Objection (6) to AW-155-17-2017 – Hard surface frontage of Brus Lodge garden - 8-11-2017

**OBJECTION TO AW/155/17/PL and HARD SURFACING FRONT GARDEN
AND THIRD PARTY'S GRASS VERGE AT 28 KINGSWAY – ALL WITHIN
The Craigweil House Conservation Area and Area of Special Character.**

Tree Retention and Protection Plan

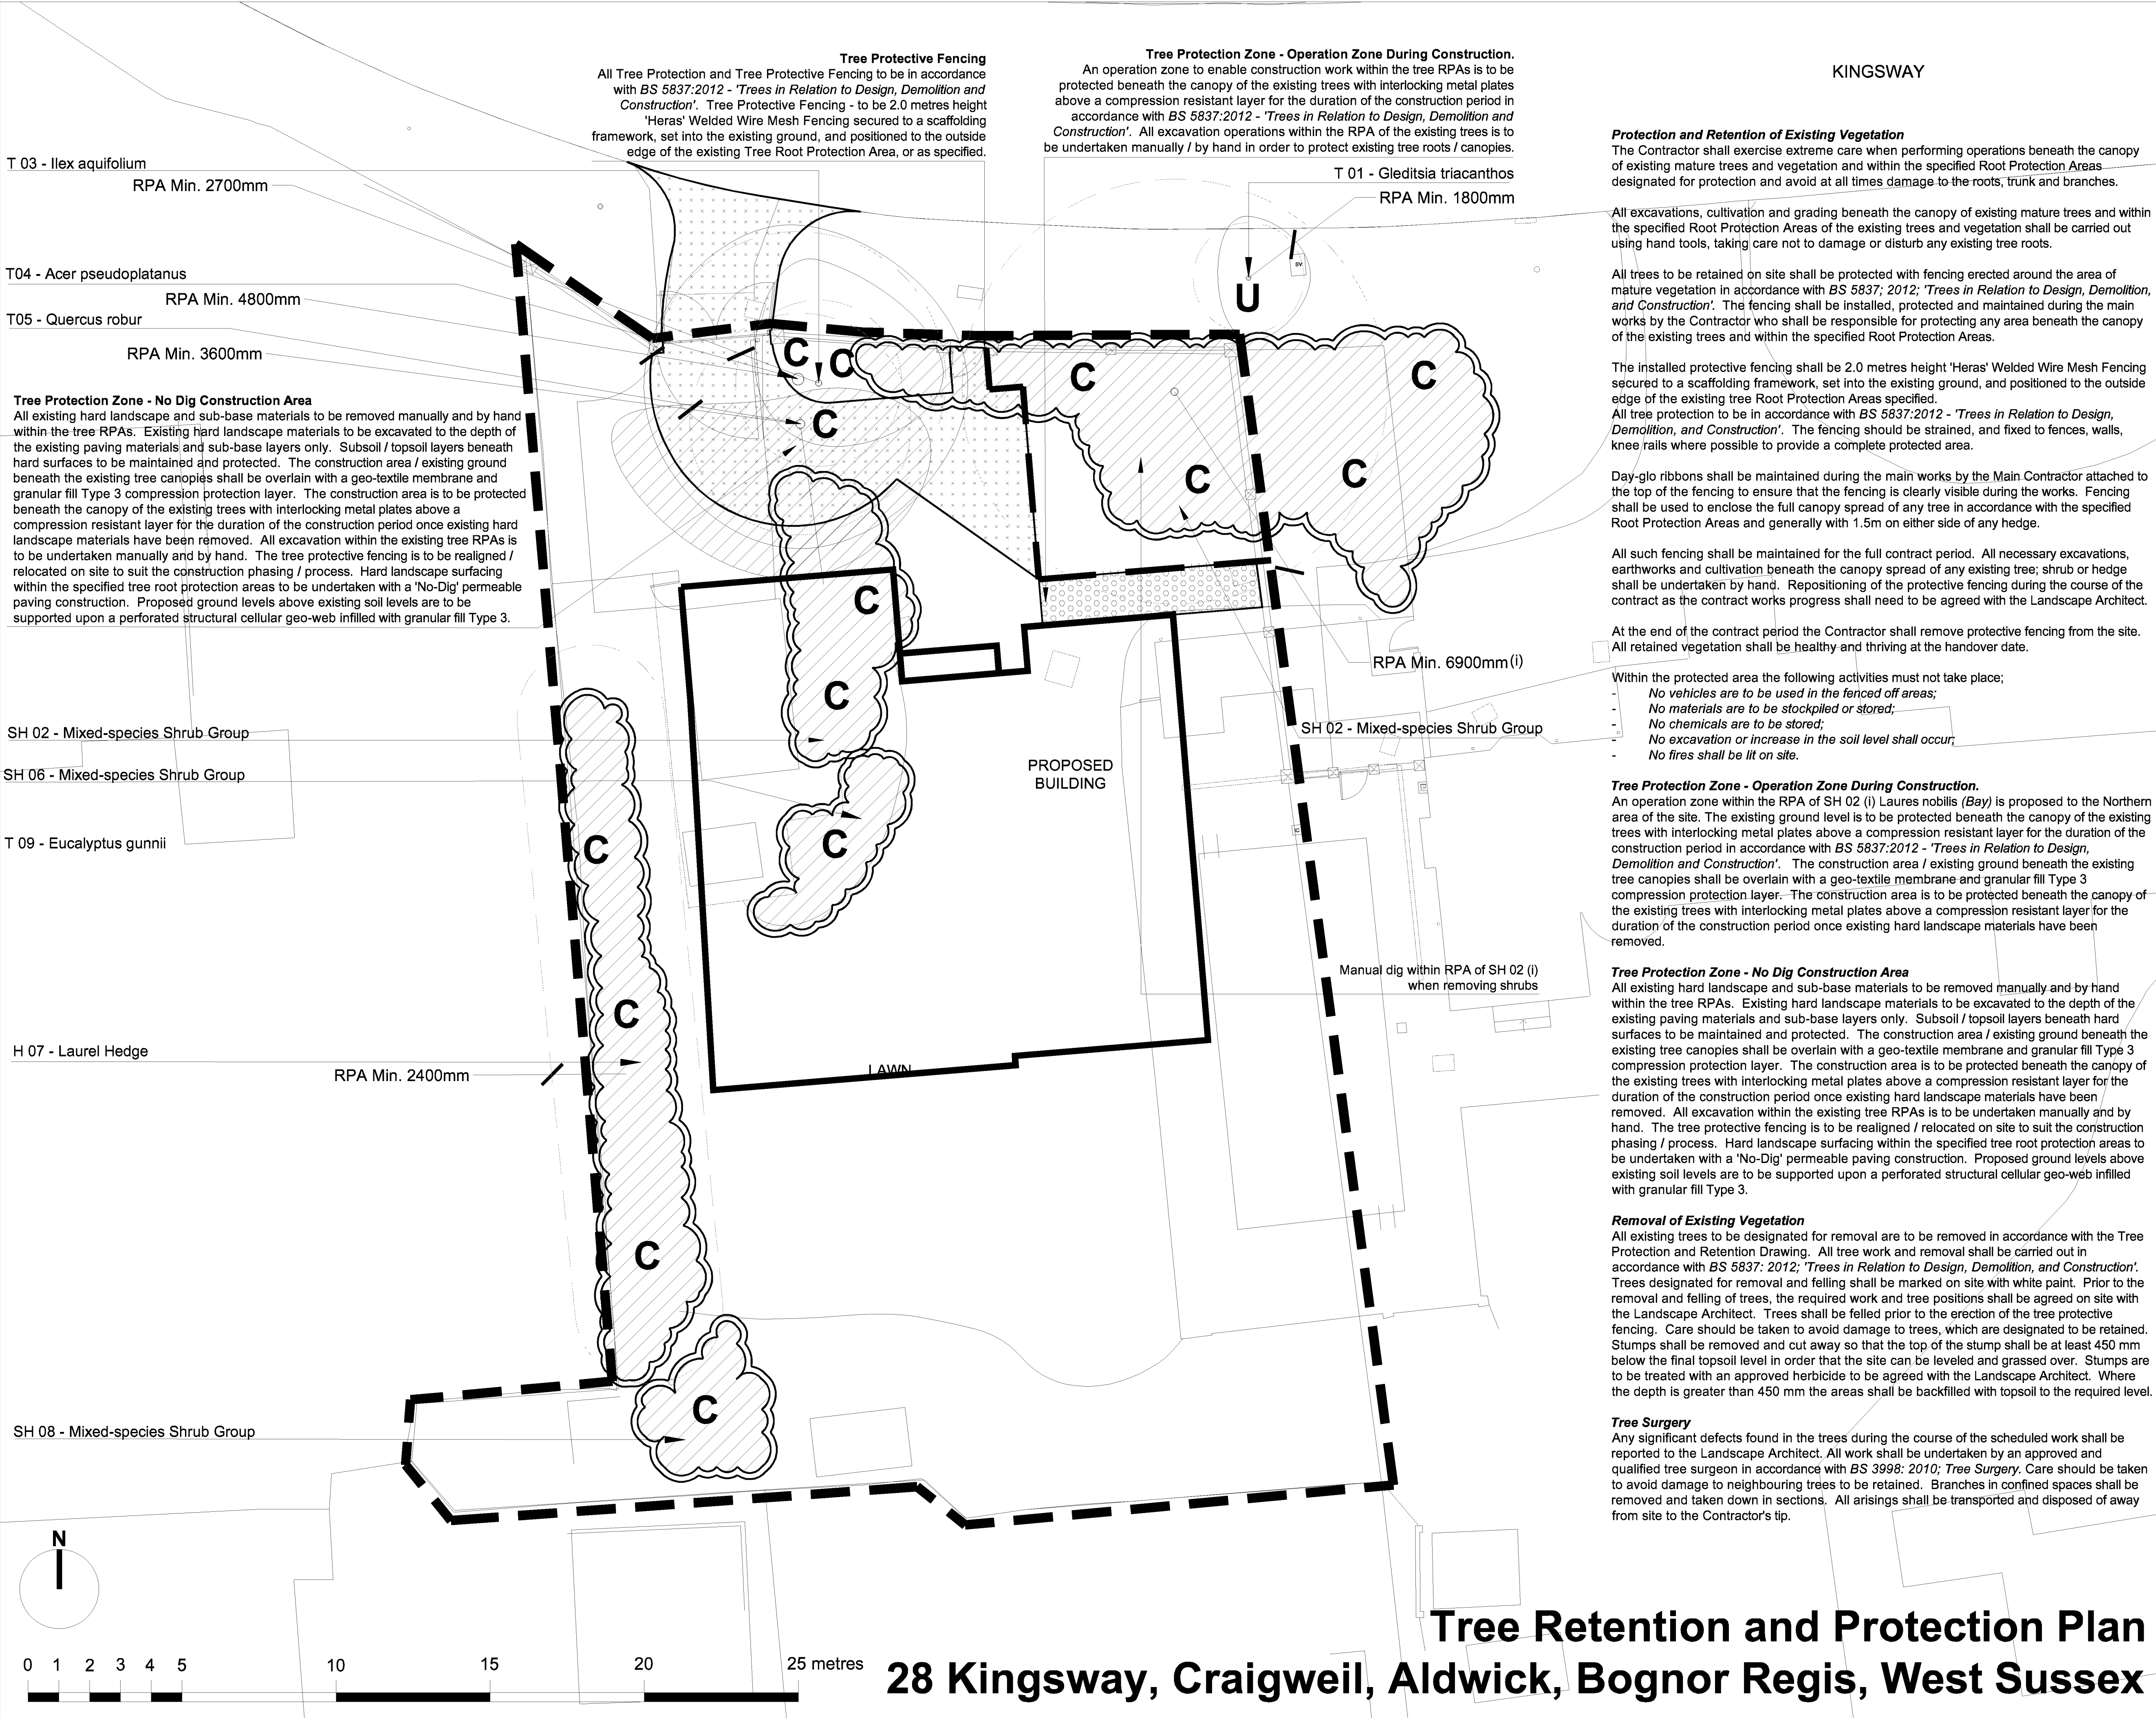
CHECAA has already sought detail of the hard surfacing proposals, and sectional construction plans to the area of garden between the proposed house and the new proposed fence but has received no information and none has been disclosed on the website from the applicant so we know nothing of this design and construction detail. **This is critically important for ensuring the preservation of the integrity of the Root Protection Areas (RPA) of many trees the applicant states are to be retained and two others which are protected by ADC Tree Preservation Order AW/1/2016. That TPO resulted from CHECAA's Consultant Arboriculturalist's recommendations.**

One tree protected by ADC is a superb and imposing Pittosporum which is in line with the proposed new central footpath entrance and the other is the magnificent Norway Maple whose trunk is immediately to the left (east) of the former Little Fellows entrance and whose RPA, through 360 degrees encompasses the whole of the verge, the existing driveway and the land to the boundary of White House, 24 Kingsway, to the west. Their RPA's each embrace the whole of the verge and, if permission is granted, these must be permanently fenced off from before start of work to completion and the land enclosed regarded as 'sacrosanct'. No storage of plant or materials may occur nor vehicle access.

All hard surfacing between the fence and the house will be directly on top of the RPA's of both protected trees, which the applicant undertakes to preserve unharmed, yet fails to explain how. The total root run will be heavily compromised if the top 600mm of ground is disturbed or excavated in any way. CHECAA firmly contends that the work cannot be done without breaching major provisions of the British Standard 5837:2012, the loss of or causing severe damage to TPO's trees.

Somewhat perversely, since the reports of Lizard Landscapes - who are NOT qualified Arboriculturalists, as is required by the British Standard - did not supply a Method Statement, or any sectional drawings which have been repeatedly requested – we repeat - for the construction of this highly sensitive area where vehicles will pass and be parked, the two Arboricultural Consultants have not had the opportunity to comment upon its adequacy.

The sensitivity of that area, in protection of the trees – particularly by the proposed, but unauthorised site entrance over CPEL's ground to a width of 3.9M – is recognised in requiring sawdust and steel protection plates to be laid BEFORE any entrance to the site commences. YET, there is no provision for its protection thereafter.

Existing + Proposed Street Elevation

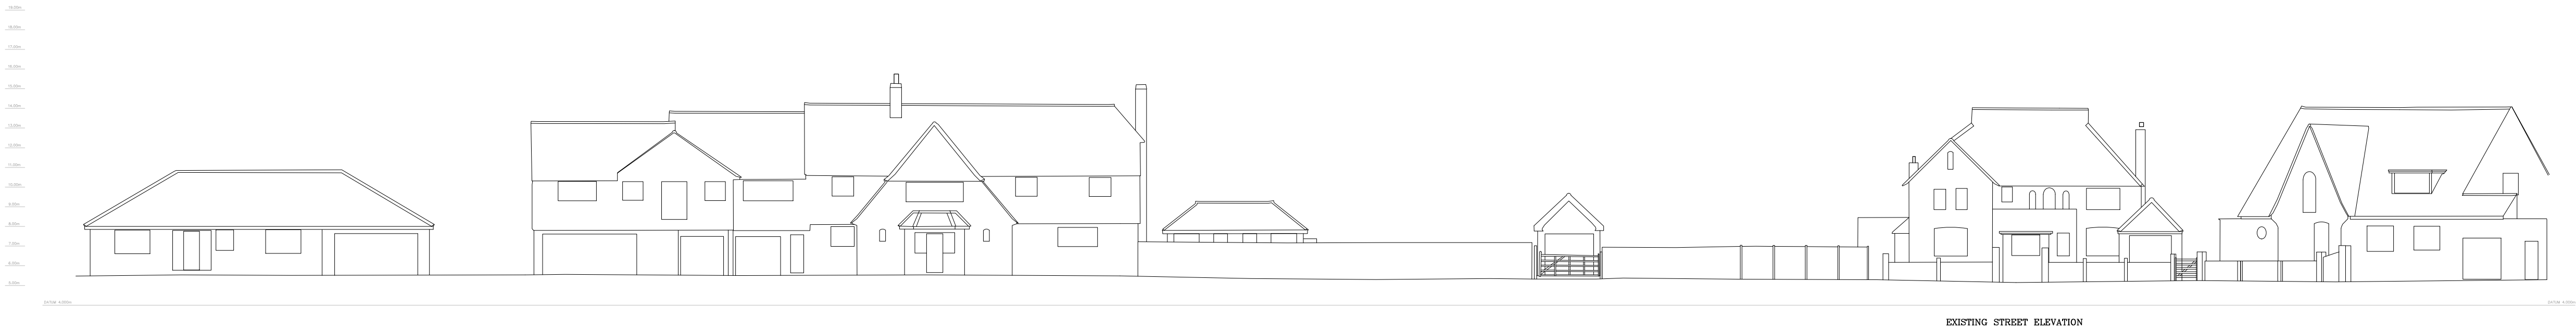
CHECAA's 200 plus members continue to be appalled by and to object to this proposed development of the intensely treed front garden of Brus Lodge, the most substantial and prominent and highly valued amenity garden feature in Kingsway, and to the proposal to replace it with the creation of a 3.9m wide vehicular entrance to the western end of the frontage and a smaller pedestrian entrance in the middle of the garden.

Both of these development proposals simply appear on plans but are not part of the planning application. Nor is there any declaration of notification to the third party owner of the verge, not of any approval by the owner to allow this land to be taken over by the applicant for any reason at all. The application fails even to address the issue of Access – a statutory integral ingredient of any development and, on that ground alone, should, we respectfully suggest, be refused by the Decision Maker.
